From: Sarah Burrow <Sarah.Burrow@arun.gov.uk>
Sent: 16 July 2021 10:16
To: Planning.Responses <Planning.Responses@arun.gov.uk>
Cc: Amber Willard <Amber.Willard@arun.gov.uk>
Subject: RE: Planning Consultation on: AL/80/21/DOC

Engineers Comments Regarding Surface Water Drainage

Application No: AL/80/21/DOC
Registered: 21st June 2021
Site Address: Stanwick Northfields Lane Westergate Chichester PO20 3UH
Description of Works: Approval of details reserved by condition imposed under ref AL/59/19/HH relating to Condition No 4 - surface water drainage.

Dwg Title: Rainwater Attenuation

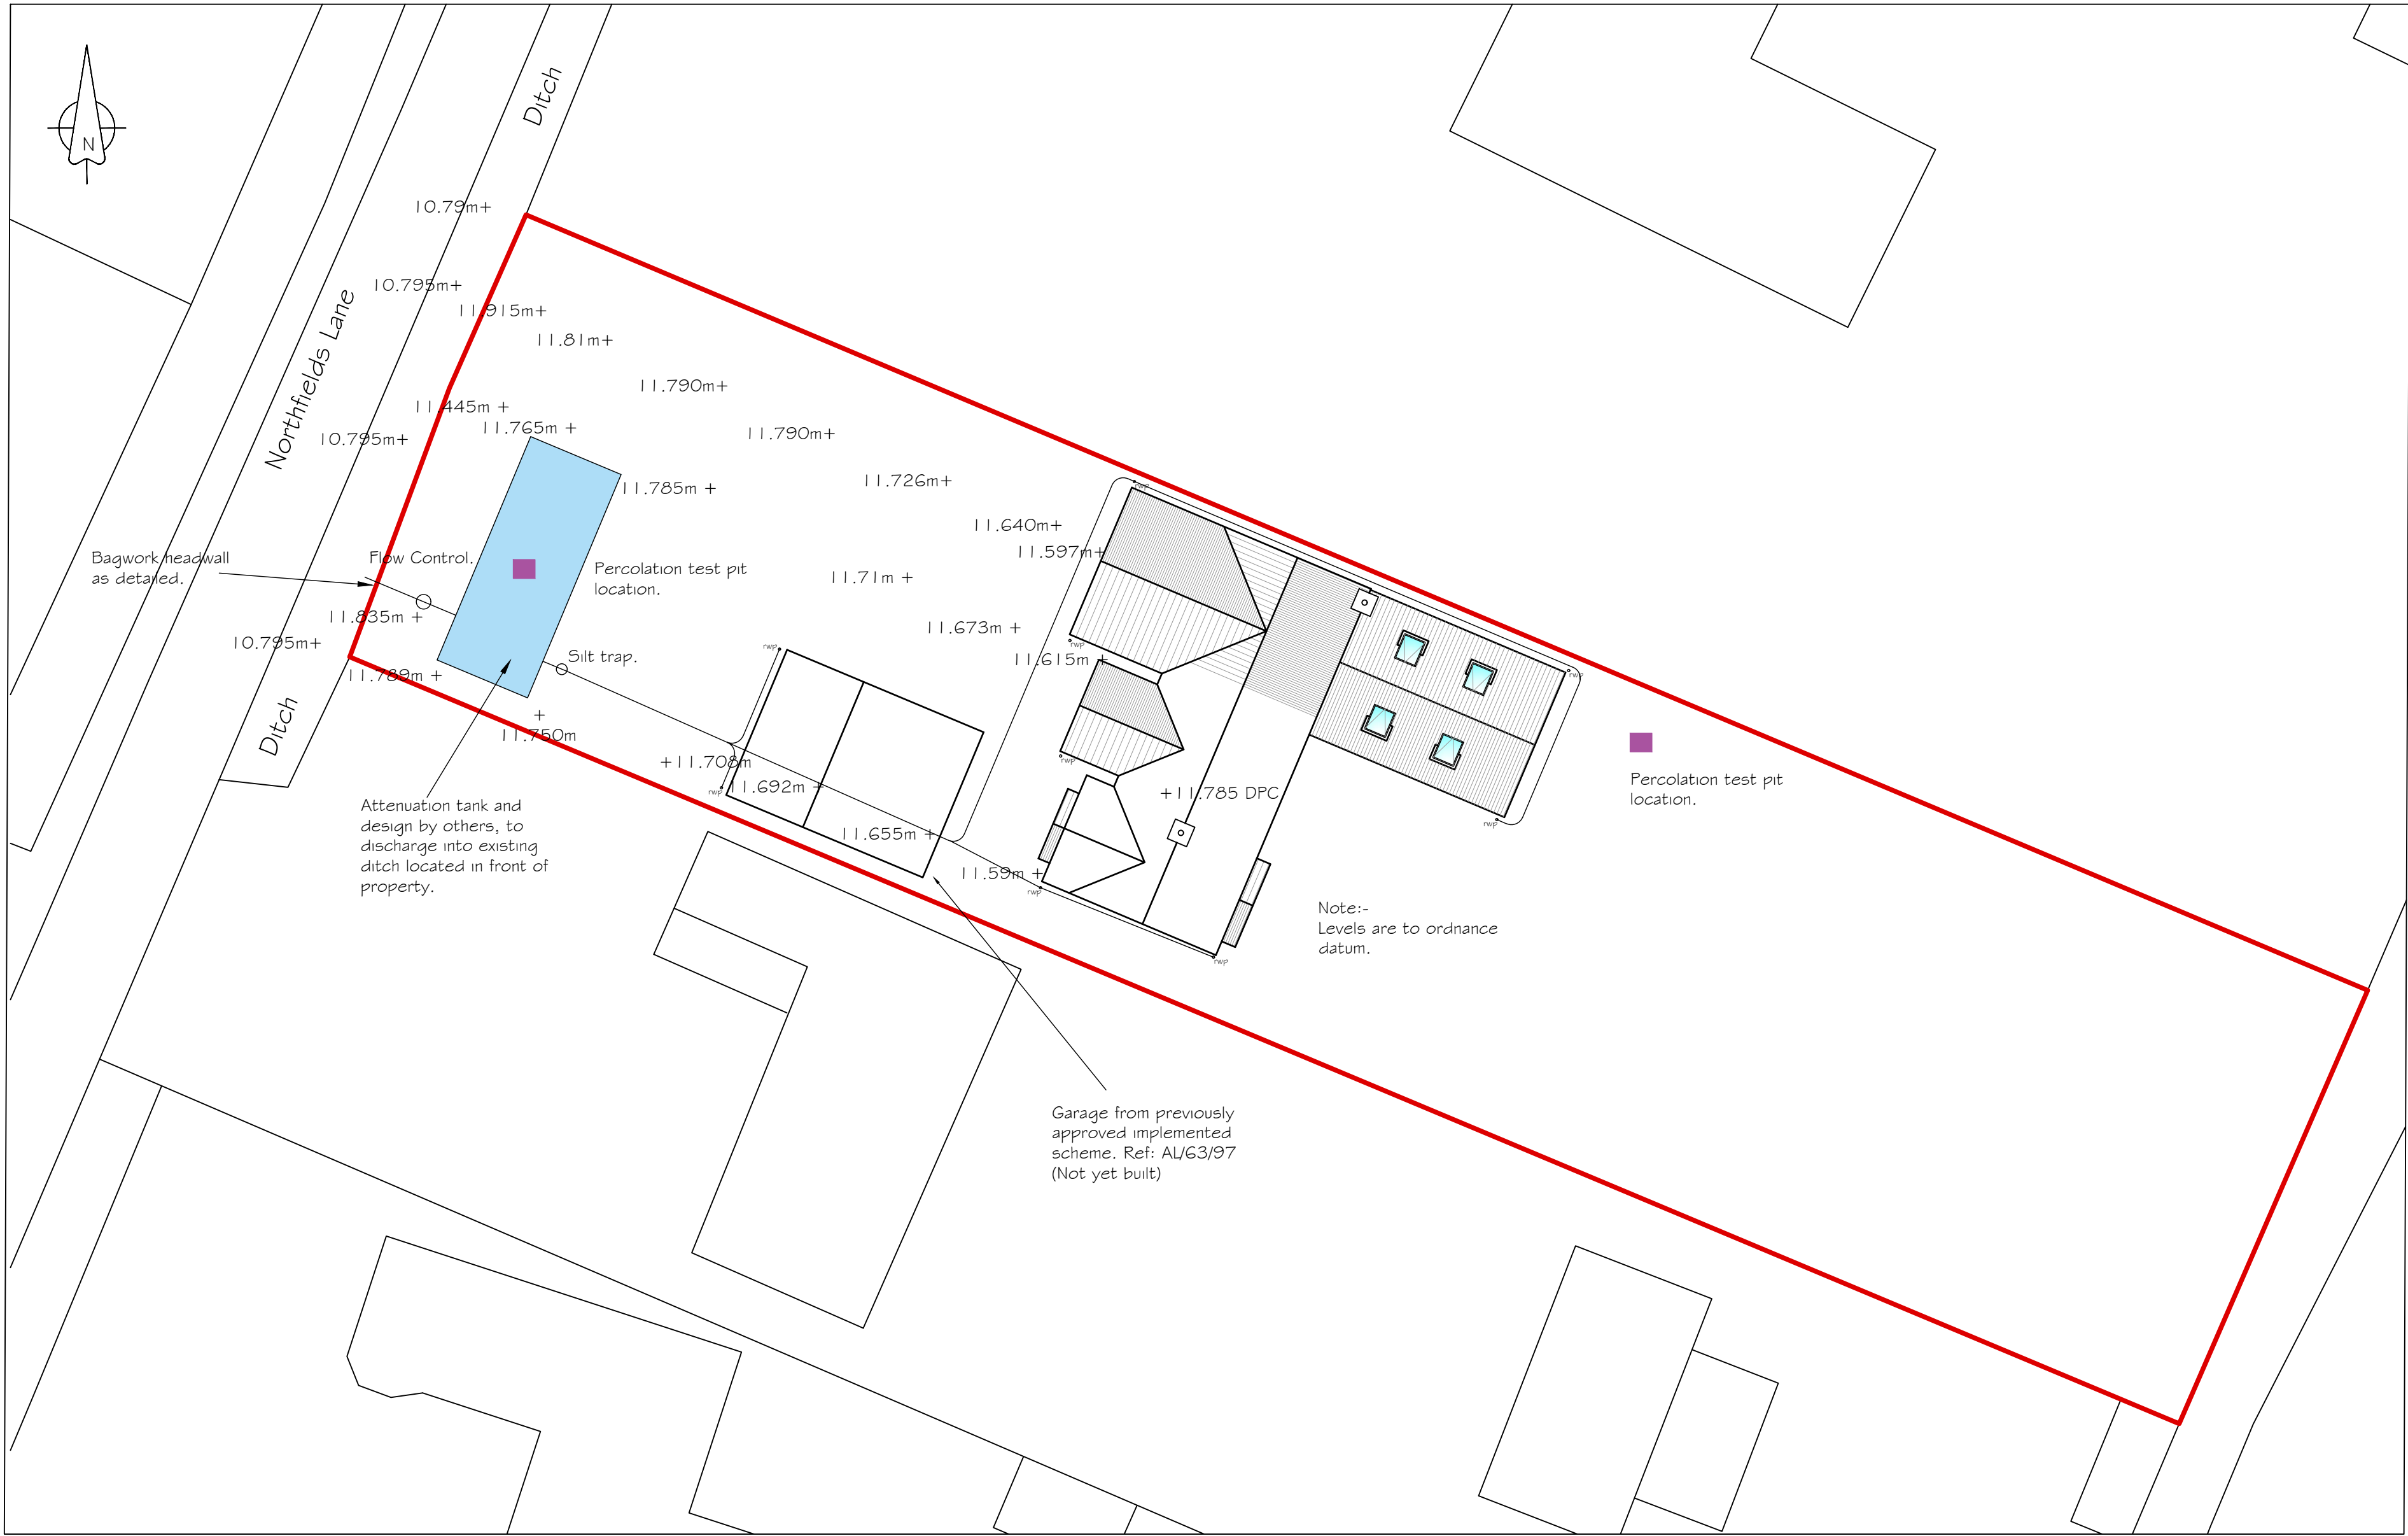
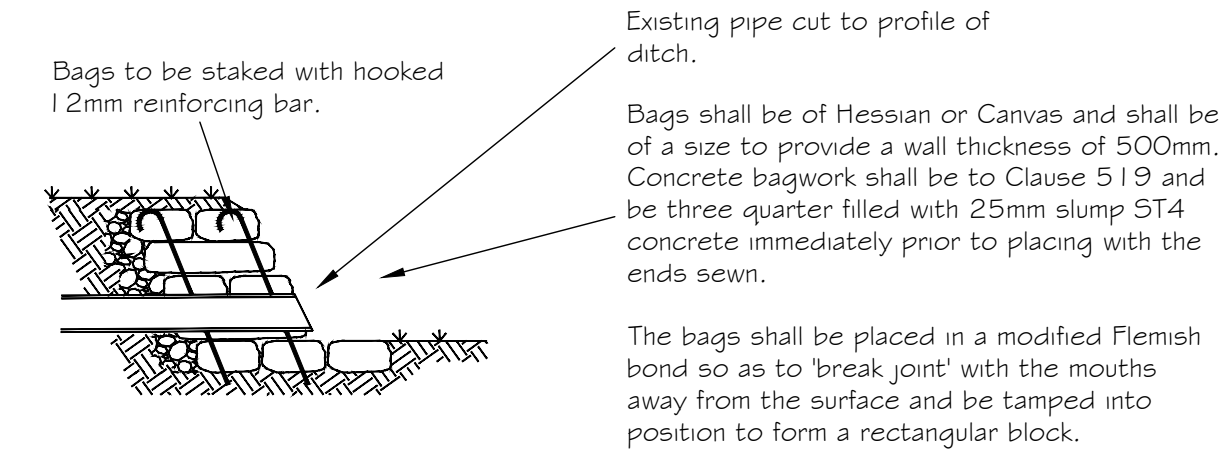
4. The drainage layout requires further detail, please label attenuation crates, silt trap and flow control with invert levels, cover levels and sump levels where appropriate. Please also label the restricted flow rate, design head and the product number on the flow control. Please encase all pipes in concrete as cover depth will be less than 600mm.

6. Headwall construction details should include hard bed, soft bed and top of bank levels. Invert levels of proposed pipes must be at least 150mm above the bed of the watercourse.

TYPICAL ATTENUATION TANK PLAN

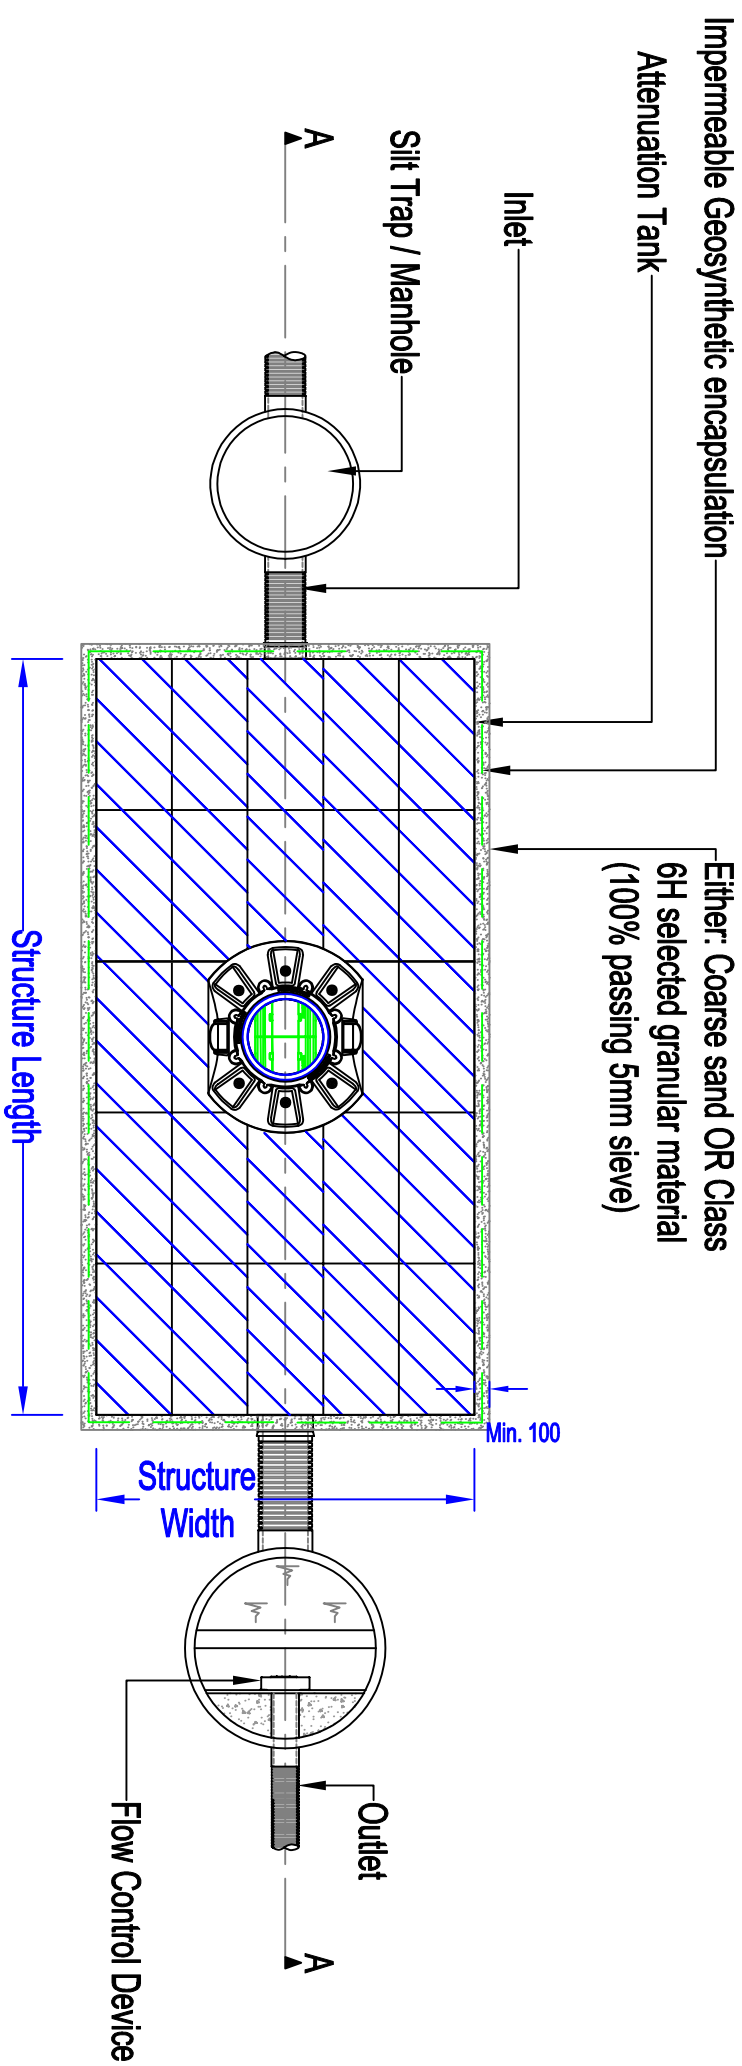
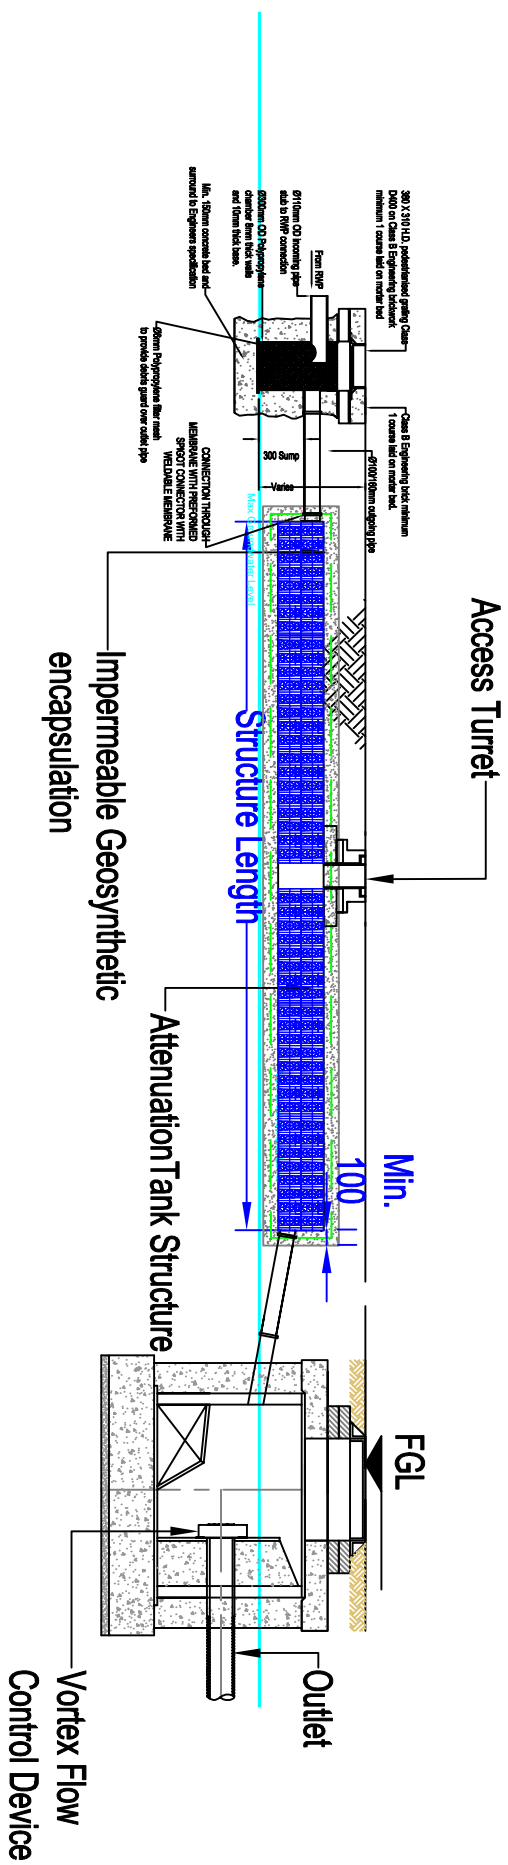
2. Please can the crates be lined with a **permeable** liner and the outflow set 50mm above the base of the tank. This will allow regular small scale events to infiltrate where possible but still ensure that high volume events can overflow to the watercourse. Within the current design there is capacity to do this and still attenuate 1 in 100 year event +40% above 500mm as there is spare storage capacity. If the capacity is reduced as a result of point 1 please ensure that the storage requirement can be met at 350mm depth. The invert level of the tank will need to be set above 0.8mbgl.

Hydro-Brake® Optimum

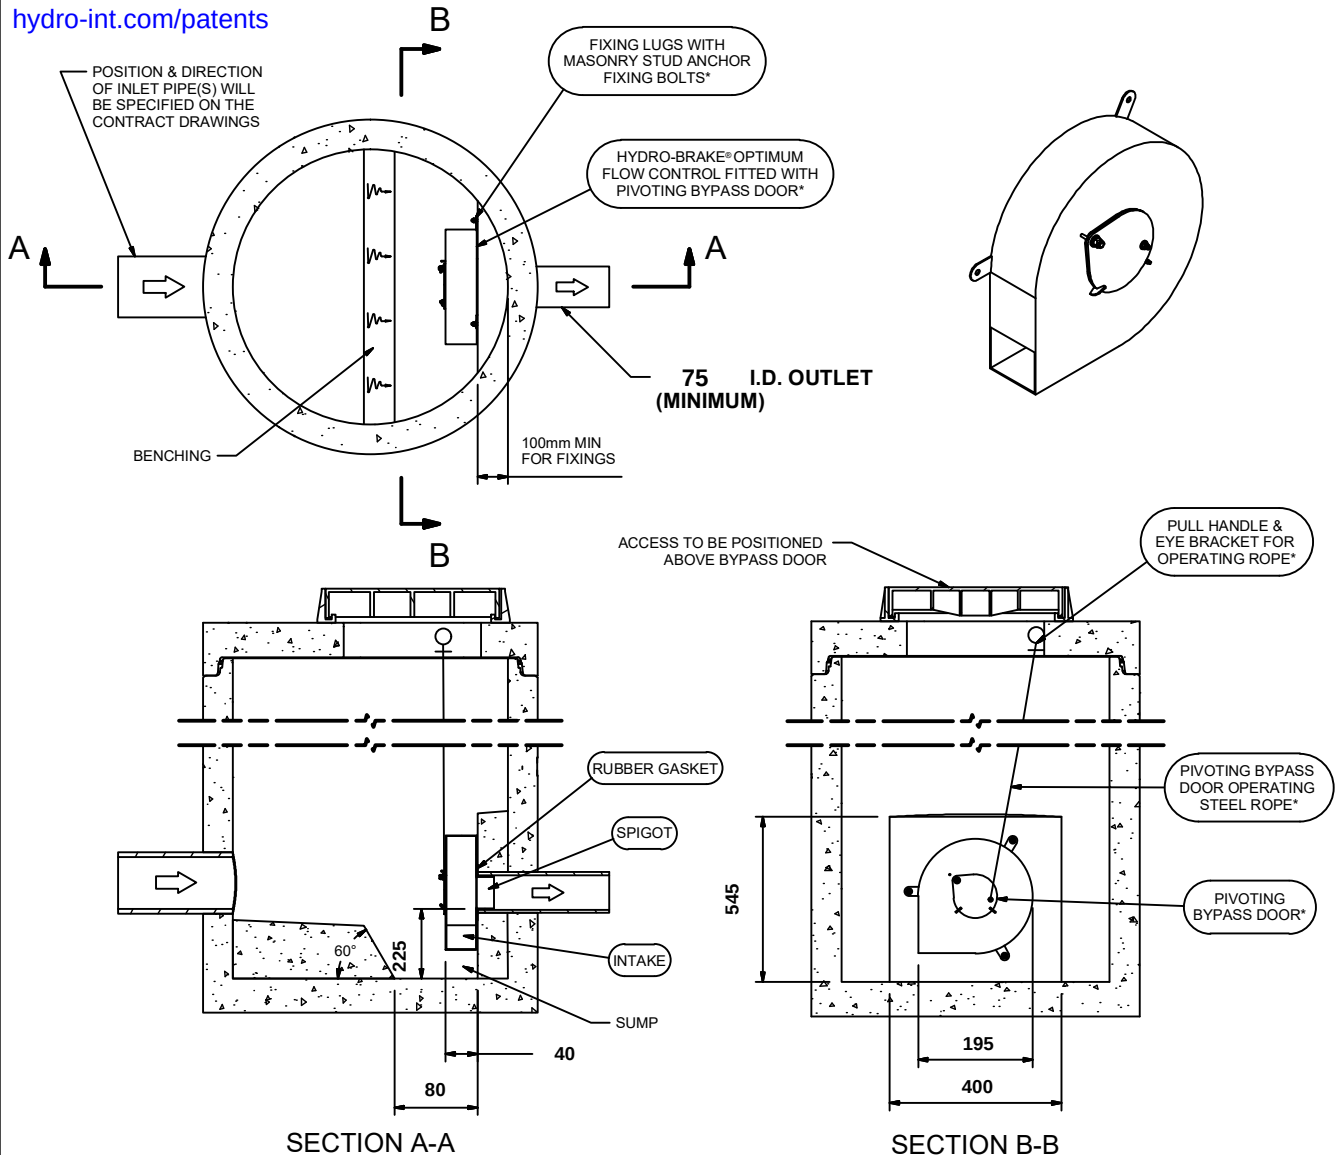
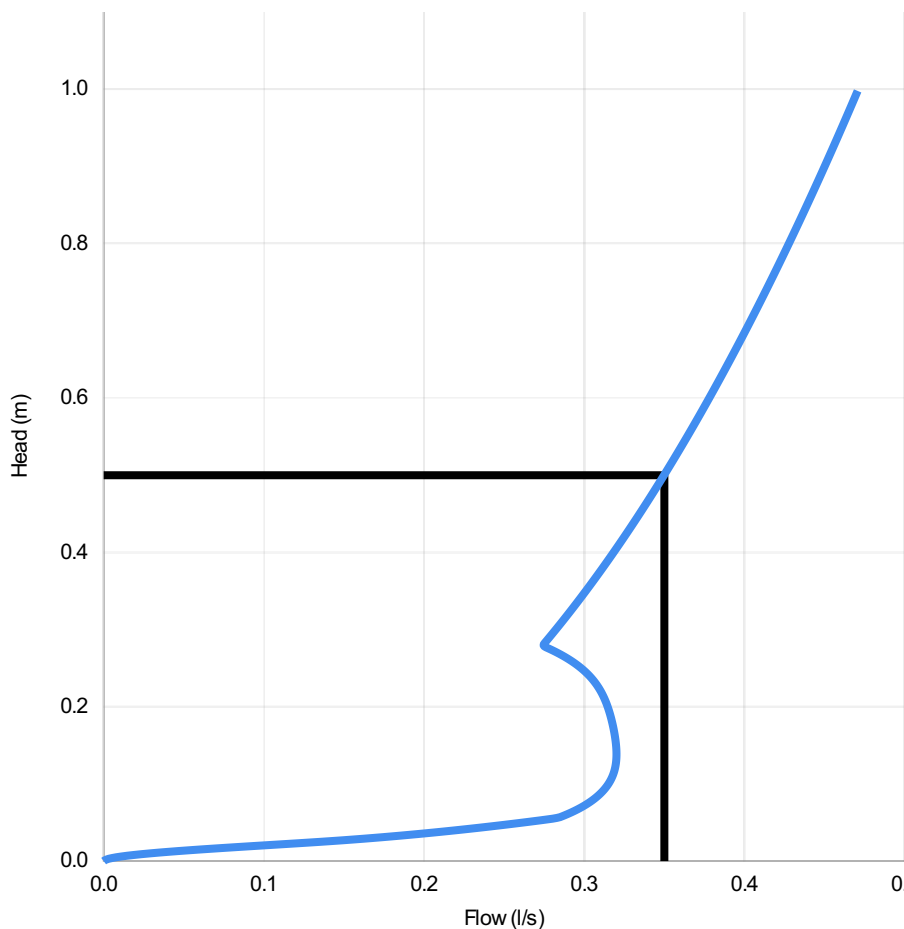
1. Please change the Hydrobrake to have a minimum aperture of 50mm. This will increase the discharge rate, we are happy to accept a discharge rate of 2l/s even though this is faster than QBAR for the site. We believe a lower discharge rate (and smaller aperture) will increase risk of blockage, and thus risk of flooding on site.

5. Hydrobrake detail should include invert level, cover level, incoming and outgoing pipe diameters and sump depth (min 300mm).
